ARVIDSON SUBDIVISION

FINAL PLAT
ARVIDSON SUBDIVISION

MVE PROJECT: 61049
MVE DRAWING: -PLAT-CS
DATE: NOVEMBER 14, 2017
SHEET: 1 OF 1

ARVIDSON SUBDIVISION

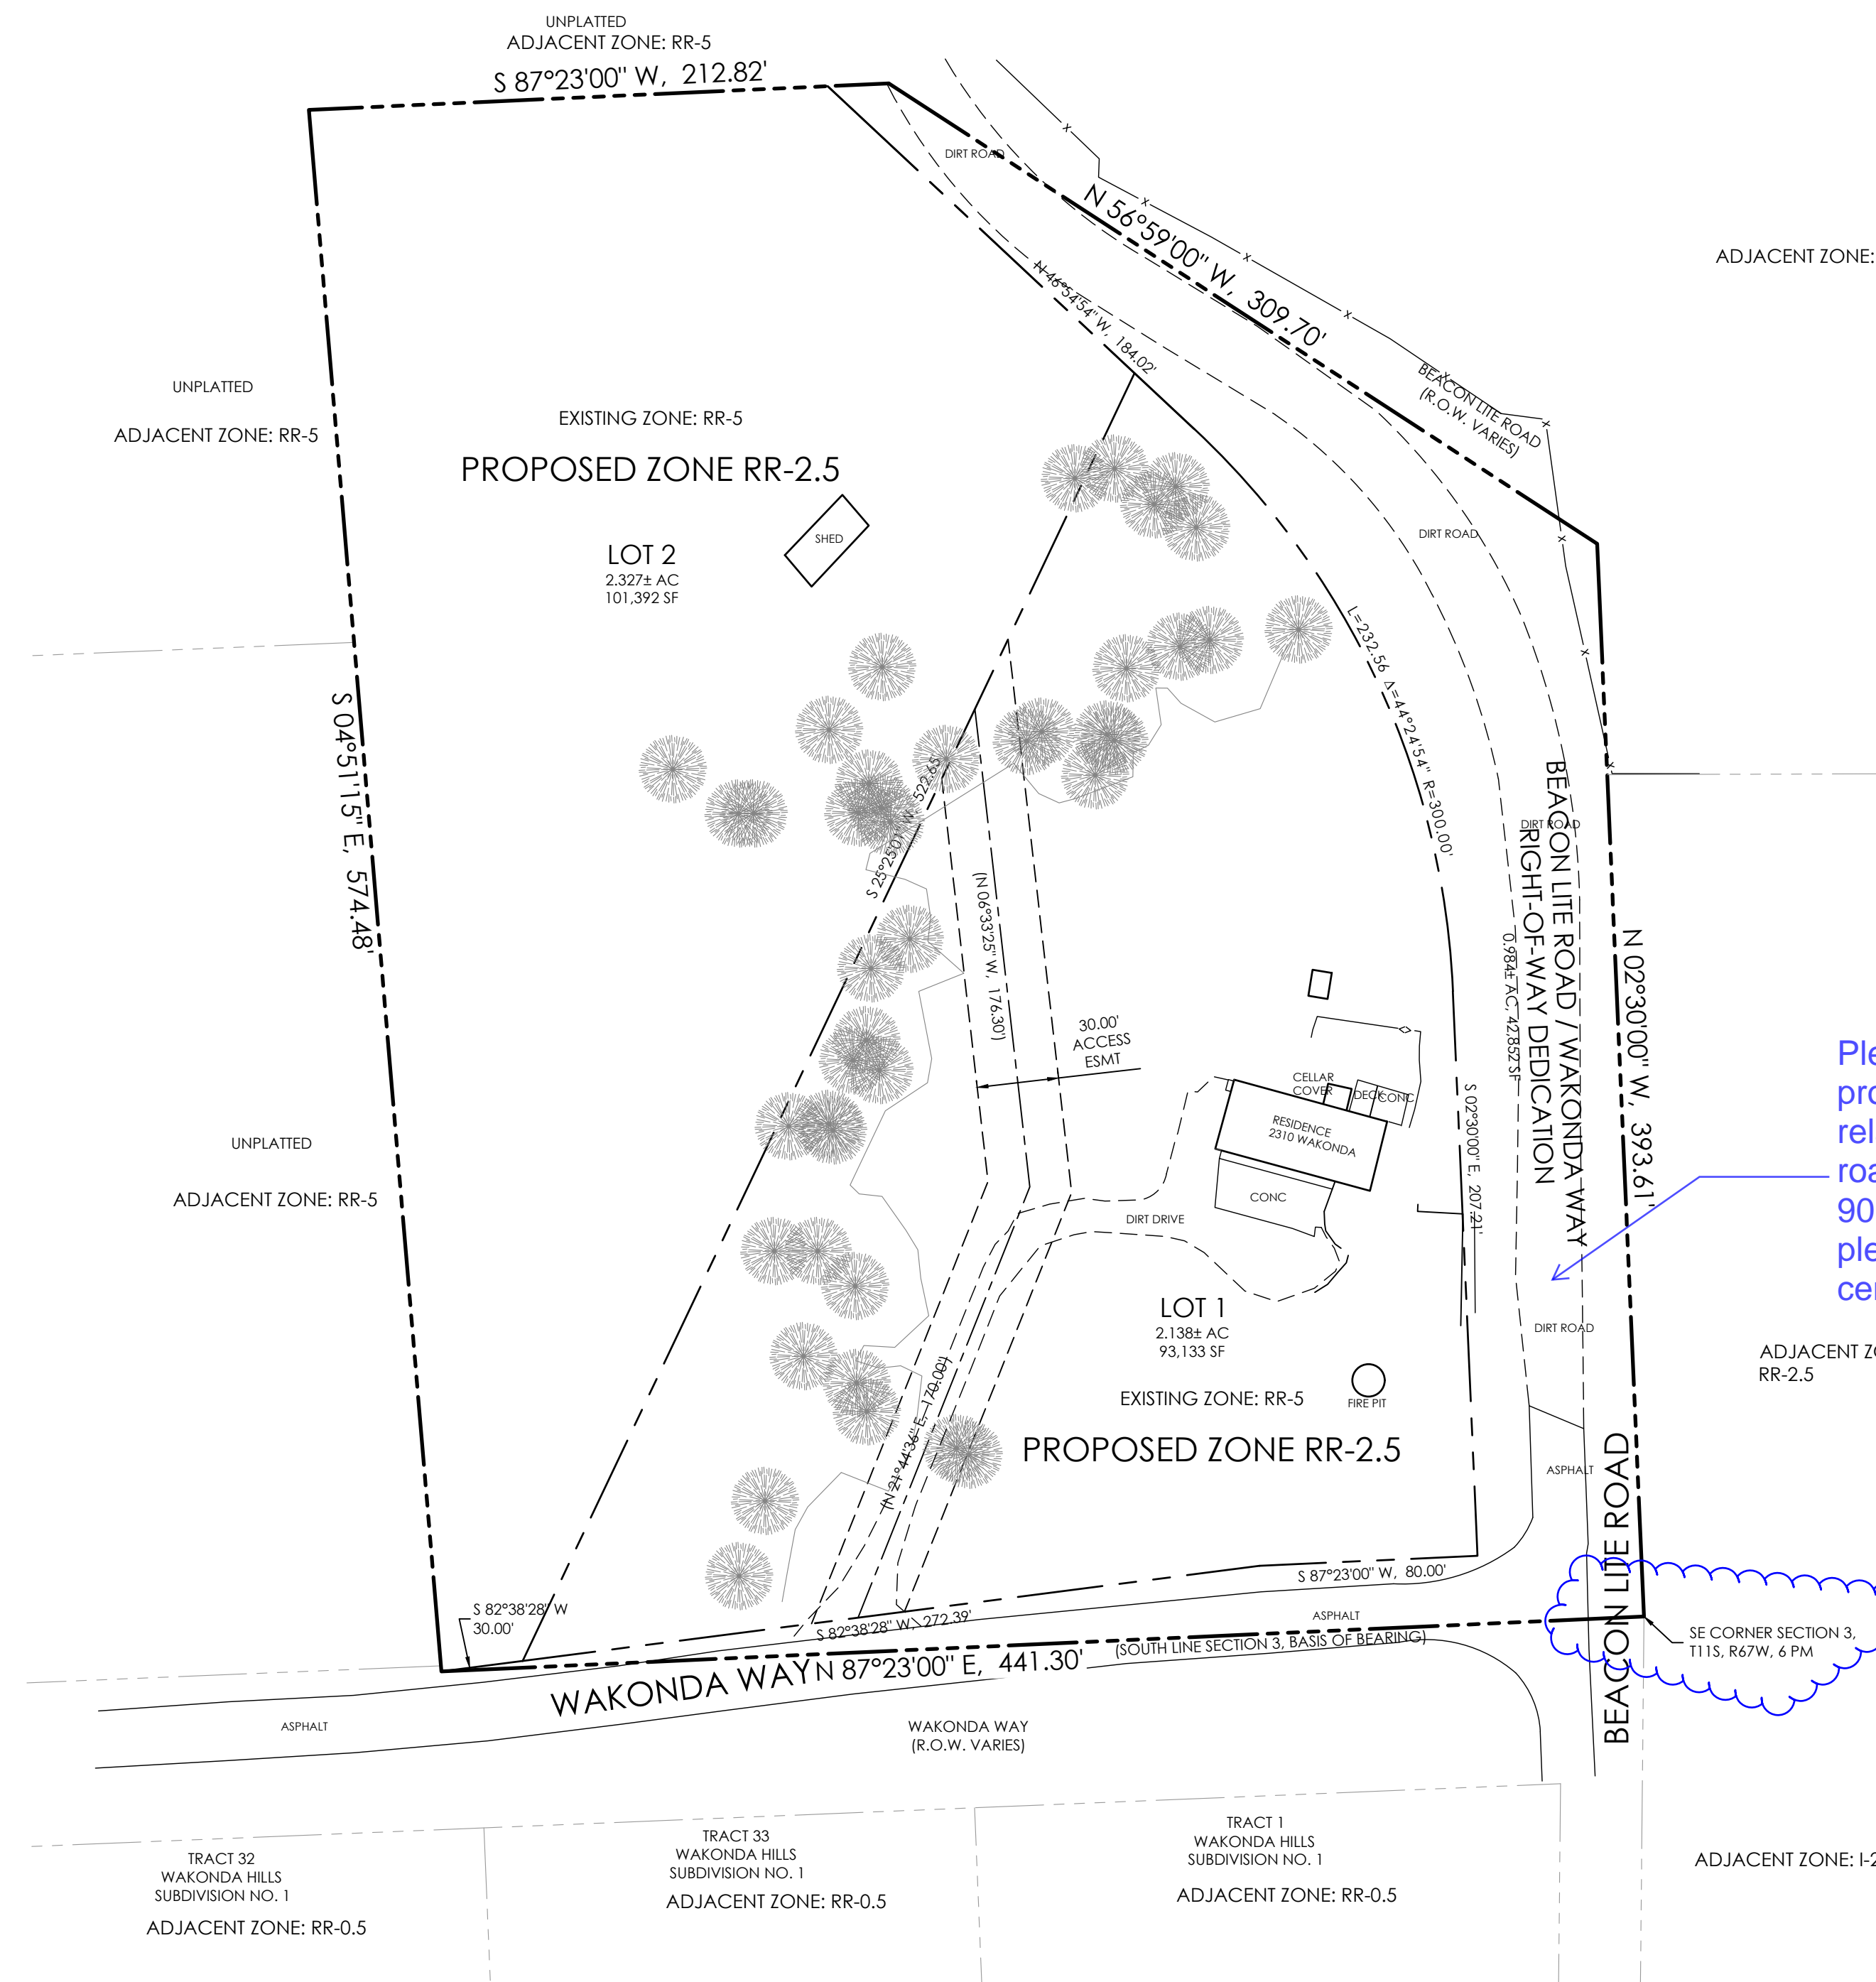
there was no TIS or Natural features report submitted, please revise text.

Please add our standard notes for: road impact, wildfire, easements, and wastewater

revise department name throughout

No public improvement are being proposed at this time. A SIA is only required if public improvements are proposed.

A BESQCP is typically the only requirement for home construction and not an ESQCP.

Please clarify that only (any) disturbance greater than 1 acre will require a GEC plan.

Add PCD File #
MS-17-006

The BoCC now has a president and our new department name is Planning & Community Development.

potential preservation of 30' ROW
